### **Kembla Grange Resource Recovery Facility – SSD 5300 MOD3 – EPA Comments**

I refer to the modification application for the Kembla Grange Resource Recovery Facility being SSD-5300-Mod-3. The application is seeking to allow for 24/7 operation of the facility, which is located at 50 Wyllie Road, Kembla Grange (the Premises). It is also seeking to vary the types of waste permitted to be received at the Premises. Environment Protection Licence No.20601 (the Licence) is currently in force and covers activities at the Premises.

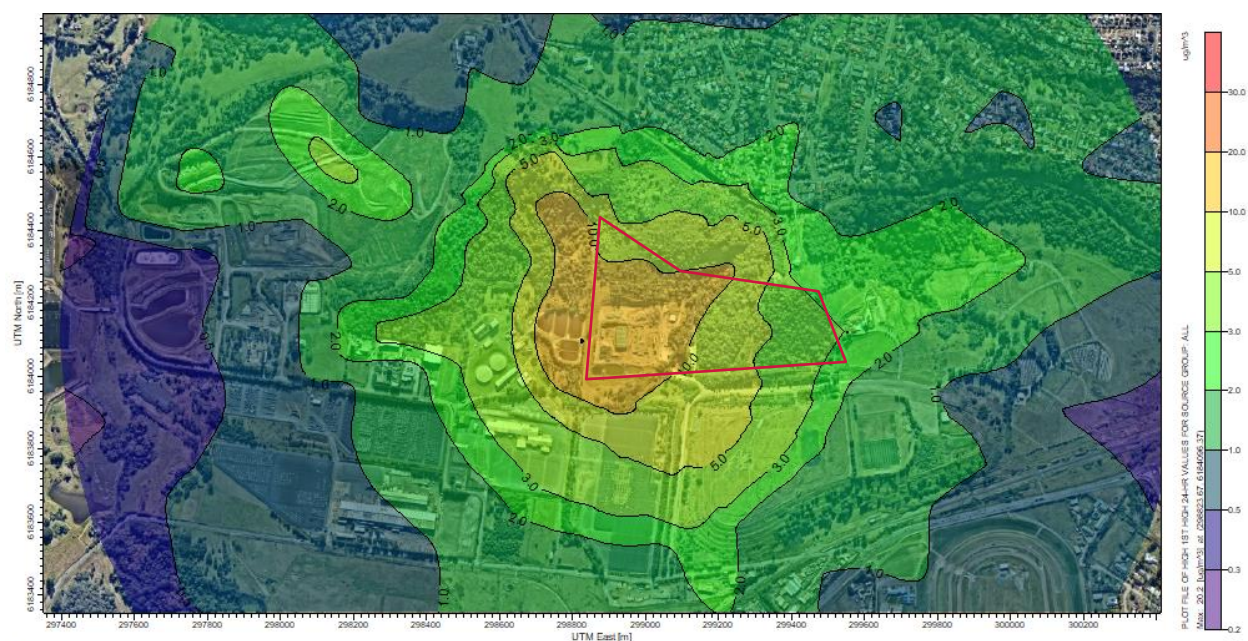
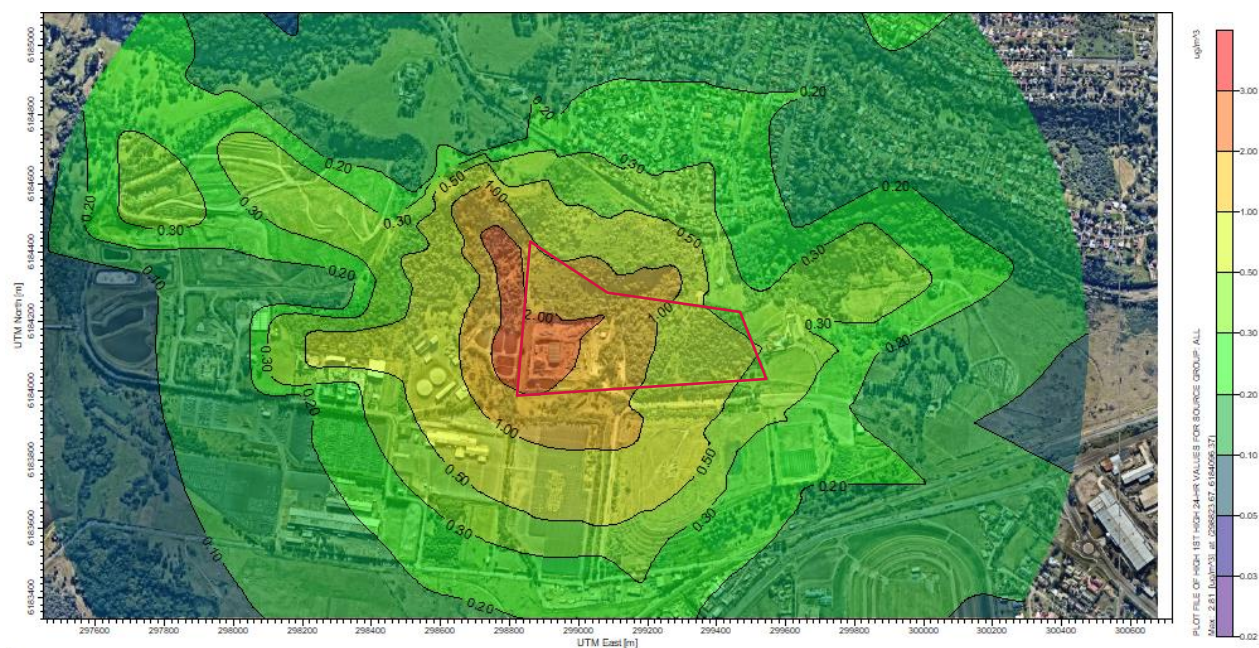
- The contour plots for PM<sub>10</sub> and PM<sub>2.5</sub> provided in Appendix C show relatively high impacts on neighbouring industrial premises.

Figure 3: Predicted One-Third Octave Band Levels

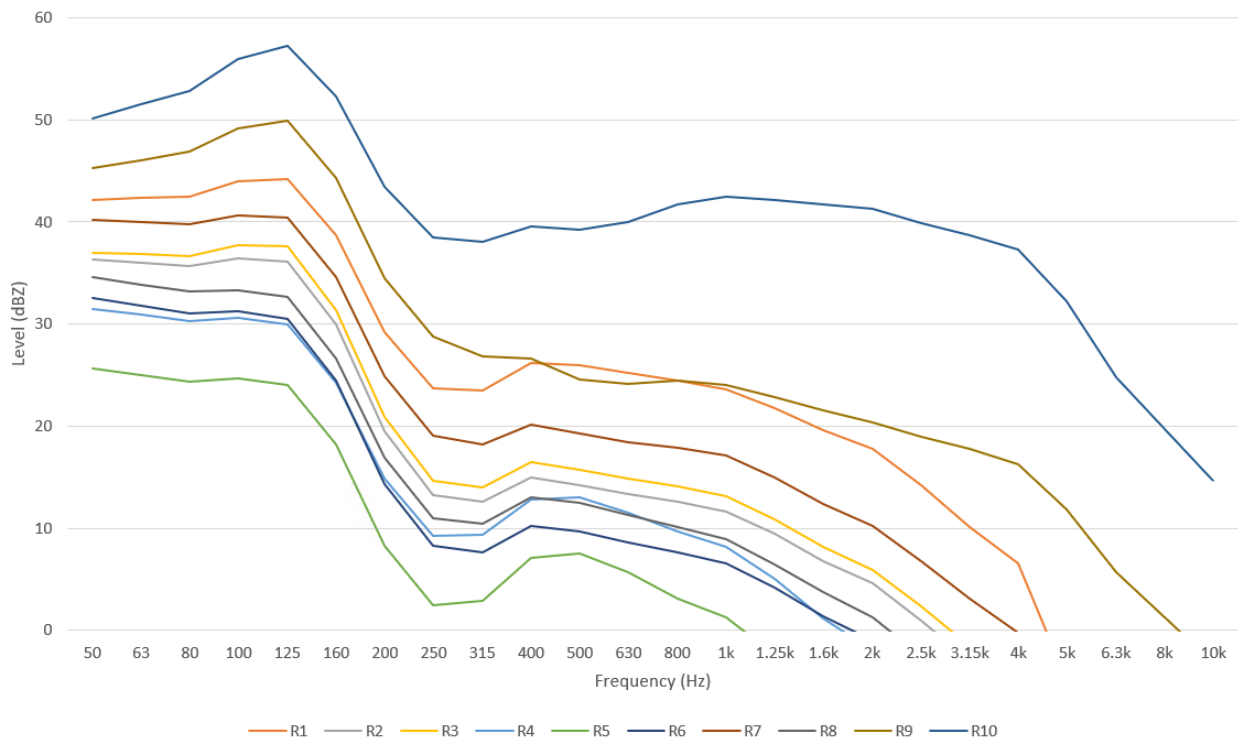
The Noise Policy for Industry (NPfI) specifies that one third octave levels are required to determine if there is a low frequency or tonal component to the predicted noise levels. The NIA states in section 5.4 that an assessment of the one third octave sound power levels has been conducted and the corrections for annoying characteristics in Fact Sheet C of the NPfI do not apply to the predicted noise levels. The spectra provided in Table 10 is in octaves, not one third octaves as required by the NPfI. **The EPA requests that the proponent provide sound power levels in one third octaves and provide more evidence to support the claim that corrections to account for annoying characteristics do not apply at the receiver.**

Figure 4: Night Noise Contours under Noise-Enhancing Meteorological Conditions

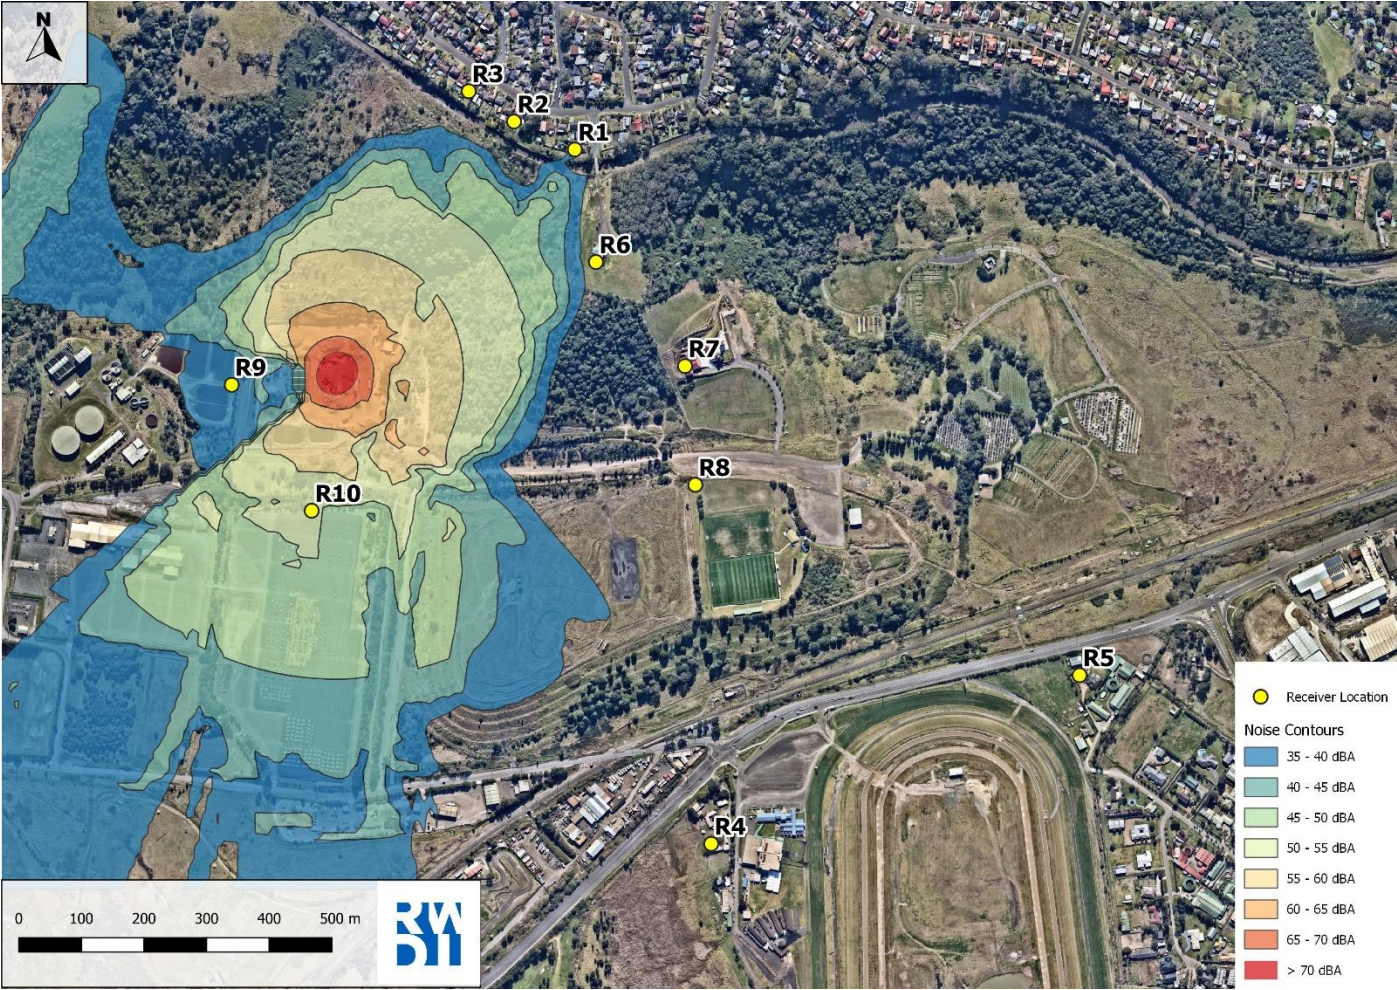
Currently the NIA is difficult to interpret because the predicted noise levels (Table 11) do not match what might be expected at the specified distances to the different receivers (Table 2). For example, Table 2 in the NIA illustrates that receiver R6 is much closer to the site than receiver R1, so it could be expected that the predicted noise level at R6 would be higher than at R1, yet the predicted noise level at R6 is 15 dB lower than at receiver R1. This is the case for each of the receivers and their corresponding predicted noise level. Without further information such as noise contour maps it is difficult to replicate / validate the predicted noise levels at each of the receivers and therefore difficult to have confidence in the predicted levels being representative of a reasonable worst-case scenario. **The EPA requests that the proponent provide the predicted noise contour maps to illustrate how the Premises and surrounding topography have been modelled.**
